Application for a Non-Material Amendment Following a Grant of Planning Permission

Number	2
Suffix	
Property Name	
Address Line 1	Kewferry Road
Address Line 2	
Address Line 3	Hillingdon
Town/city	Northwood
Postcode	HA6 2PD

46478/APP/2026/1053

Rev	B - Sept 2026	
Rev	A - JULY 2026	
Project	2 Kewferry Road Northwood HA6 2PD	
Drawing Title	Proposed Elevations	
Drawing Title	2 /P/D1	Rev. B
	Scale: 1: 100 @ A3	Date: Sept 2026

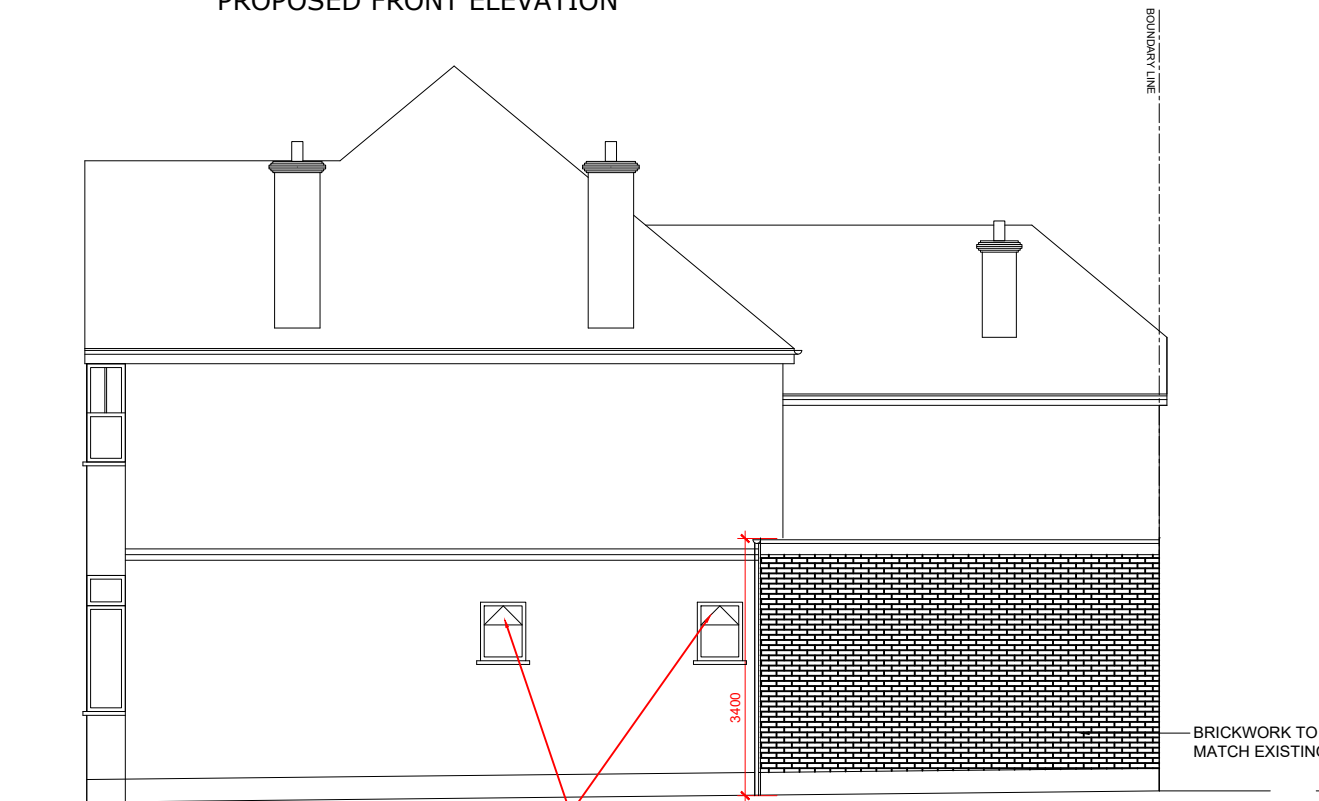
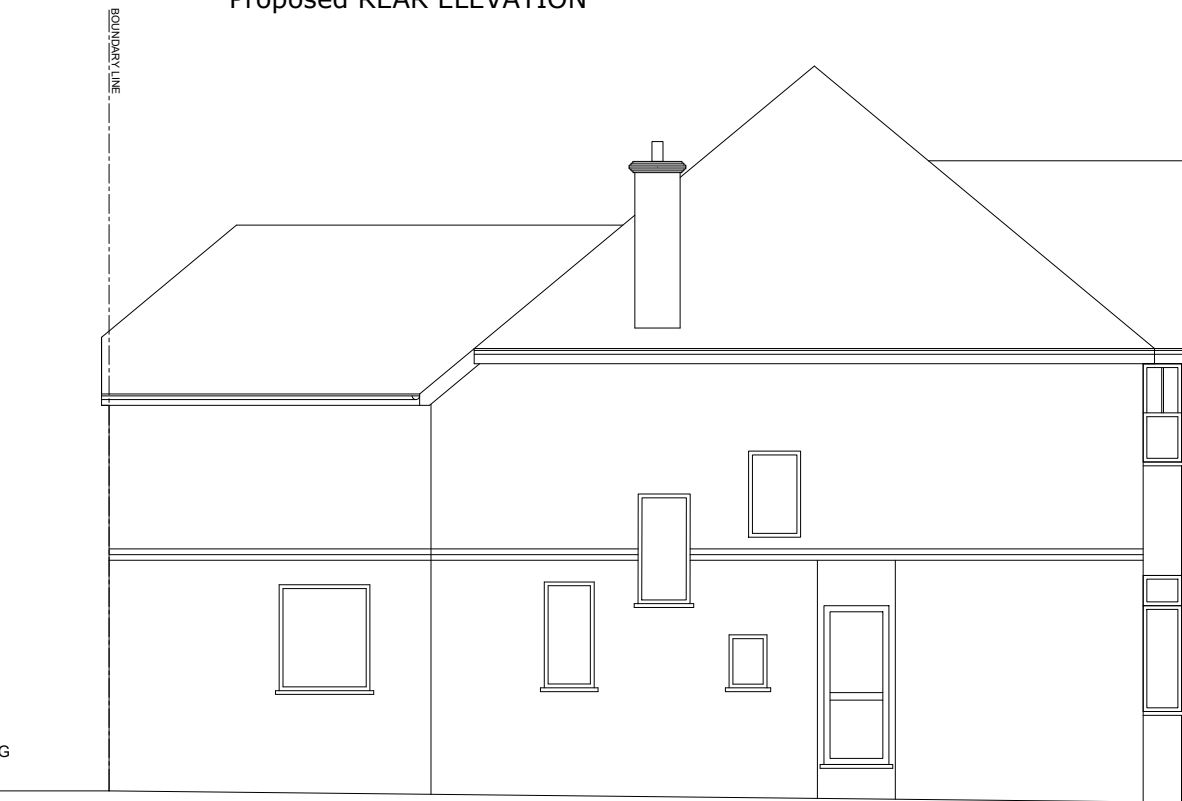
1. The approved external height of the extension is 3m. Because the existing floor level of the house is raised, matching the extension's finished floor level to it has resulted in an internal head height within the extension of only 2.0m, which is impractical for habitable use.
2. Removal of rooflight.
3. Window to be 1m2.

1. To resolve this, I would like to apply for a non-material amendment to increase the external height of the extension by 0.4m, from 3m to 3.4m. This would bring the internal head height up to approximately 2.4m, matching the internal height of the remainder of the property. This makes the space usable, while leaving the extension's footprint, position, and all other approved details unchanged.
2. Rooflight removed to reduce an more impact of raising the roof from 3m to 3.4m.
3. Installation of 1m2 window for the purpose of fire escape only.
